Appeal Decision

Appeal Ref: APP/R4408/D/18/3210579

4 Burton Crescent, Monk Bretton, Barnsley, S71 2QD

- The appeal is made under section 78 of the Town and Country Planning Act 1990 against a refusal to grant planning permission.
 - The appeal is made by Mr Cyril Barnet against the decision of Barnsley Metropolitan Borough Council.
 - The application Ref 2018/0616, dated 10 May 2018, was refused by notice dated 20 June 2018.
 - The development proposed is an annex to existing dwelling.
-

FRONT ELEVATION
AS PROPOSED

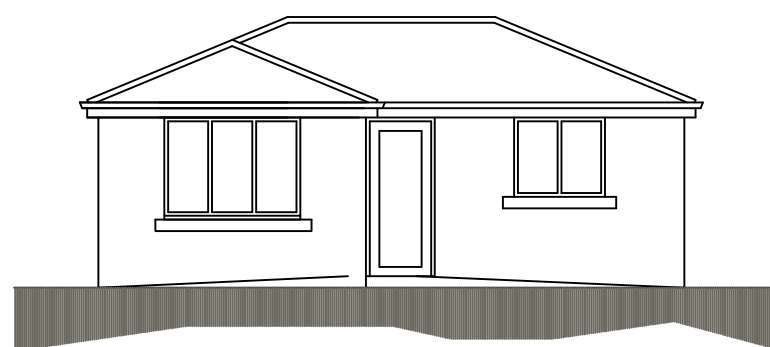
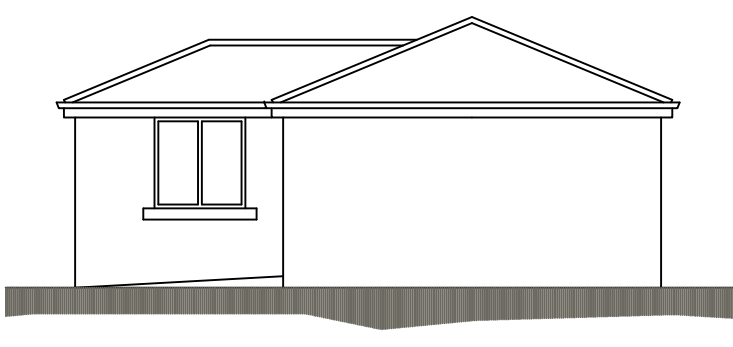
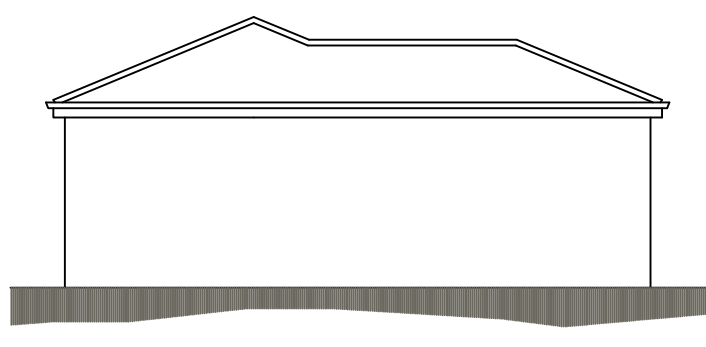
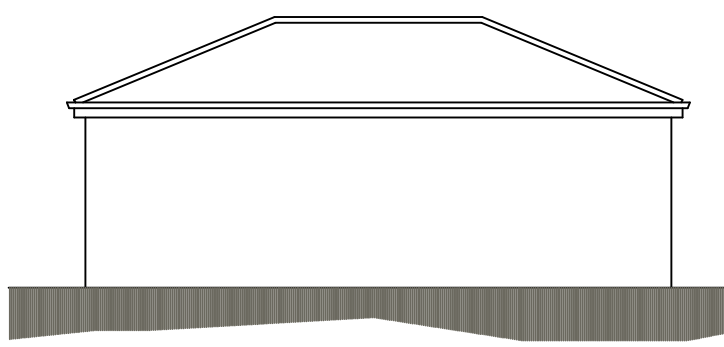
7. The proposed development would comprise an L-shaped, single storey building with a hipped roof. It would have a relatively large footprint, such that it would extend across the majority of the width of the rear garden. The proposal would have the appearance of a small bungalow.

8. During my site visit, I observed that, whilst there are a number of built features in rear gardens, these tend to comprise small scale and largely wooden constructions, such as garden sheds. By way of significant contrast, the proposal would comprise a large, tall, bulky brick-built building. This would, due to its scale and form, appear unduly dominant in the rear garden and would draw attention to itself as an incongruous feature, out of character with the smaller scale outbuildings more common to rear gardens in this location.

12. However, the proposal would result in the creation of two windows and a door facing directly towards Burton Crescent. During my site visit, I observed that the first floor windows of both Nos 2 and 6 Burton Crescent overlook the rear garden of No 4. The proposed windows and door – which would provide the only access and egress from the proposal – would, I find, greatly increase the scope for overlooking between the proposal and neighbouring dwellings. The harm to privacy arising from this may also be exacerbated by the close proximity of the proposed development to these neighbouring properties.

SITE PLAN
SCALE 1:500

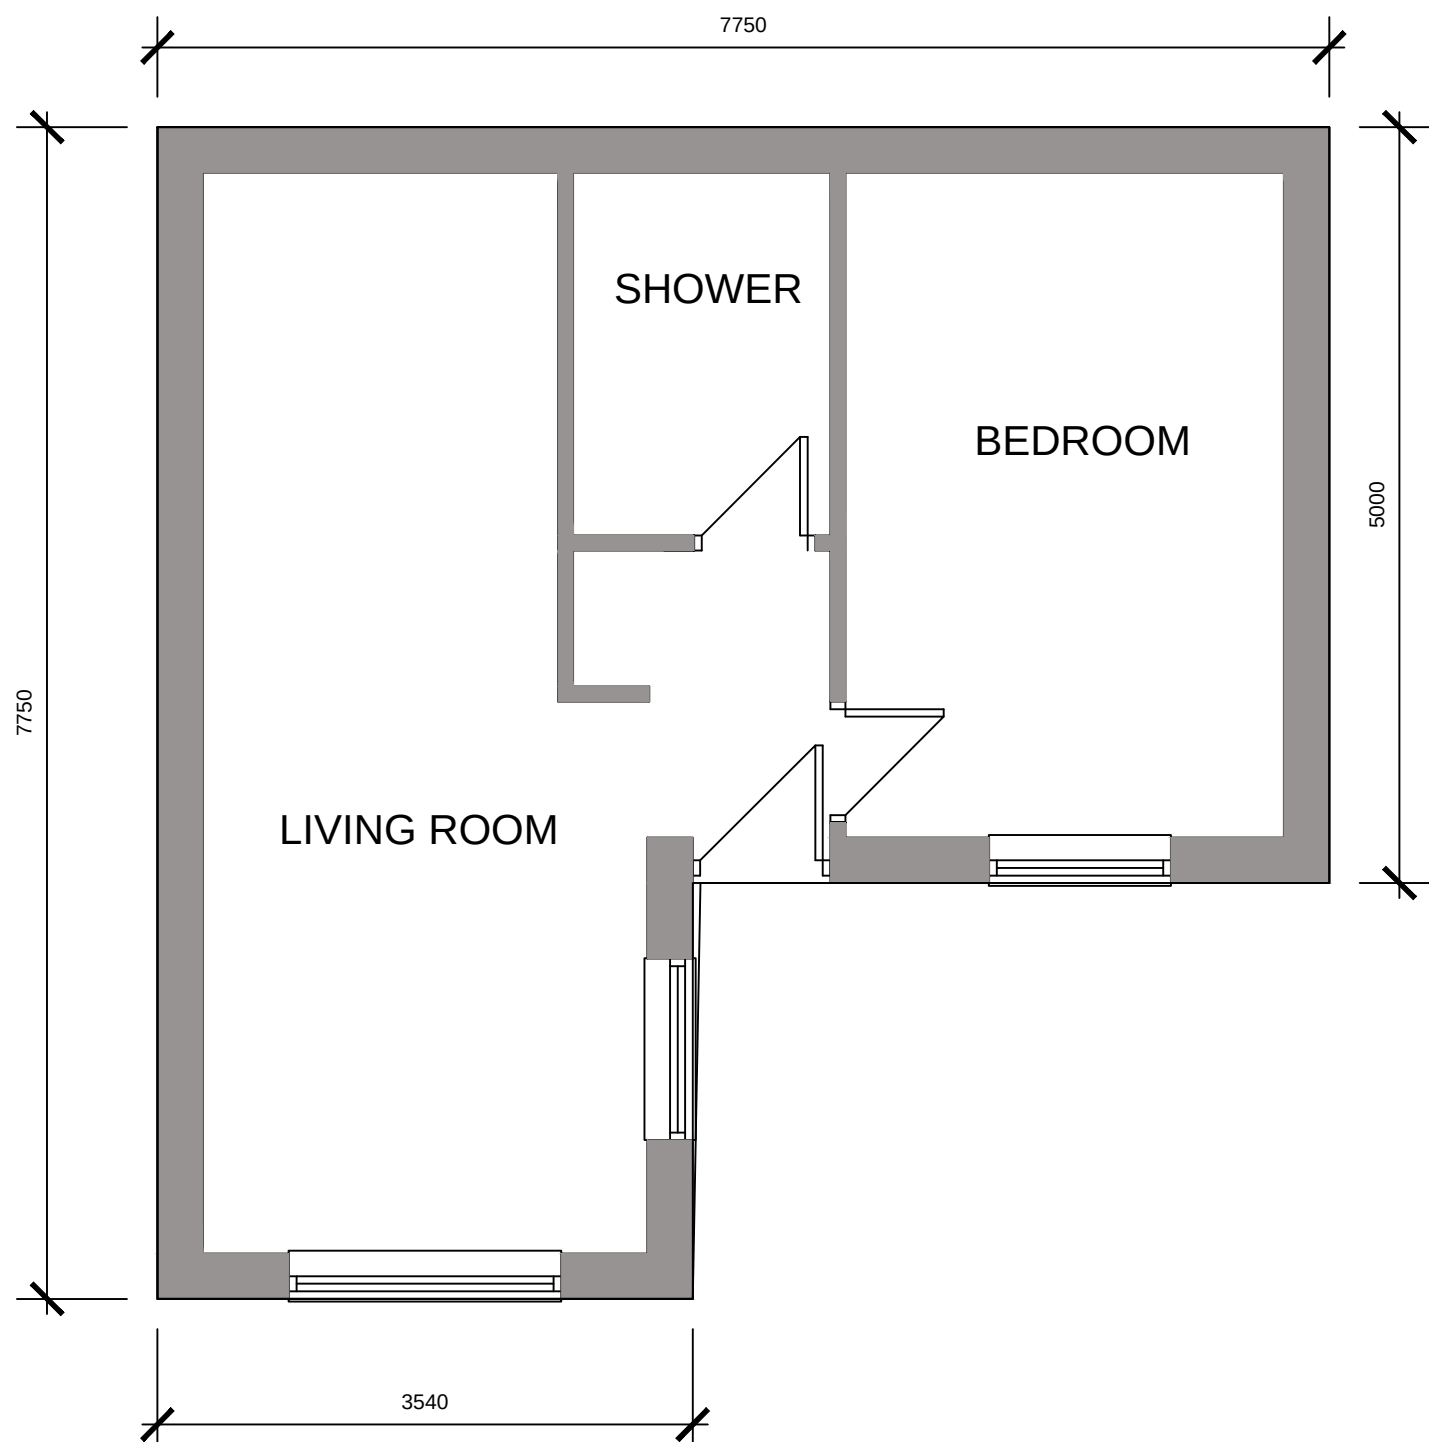
9. Further to the above, I find that the proposal would introduce considerable built form where none currently exists. The effect of this would be detrimental to the green and spacious attributes of the area that currently make a positive contribution to local character.
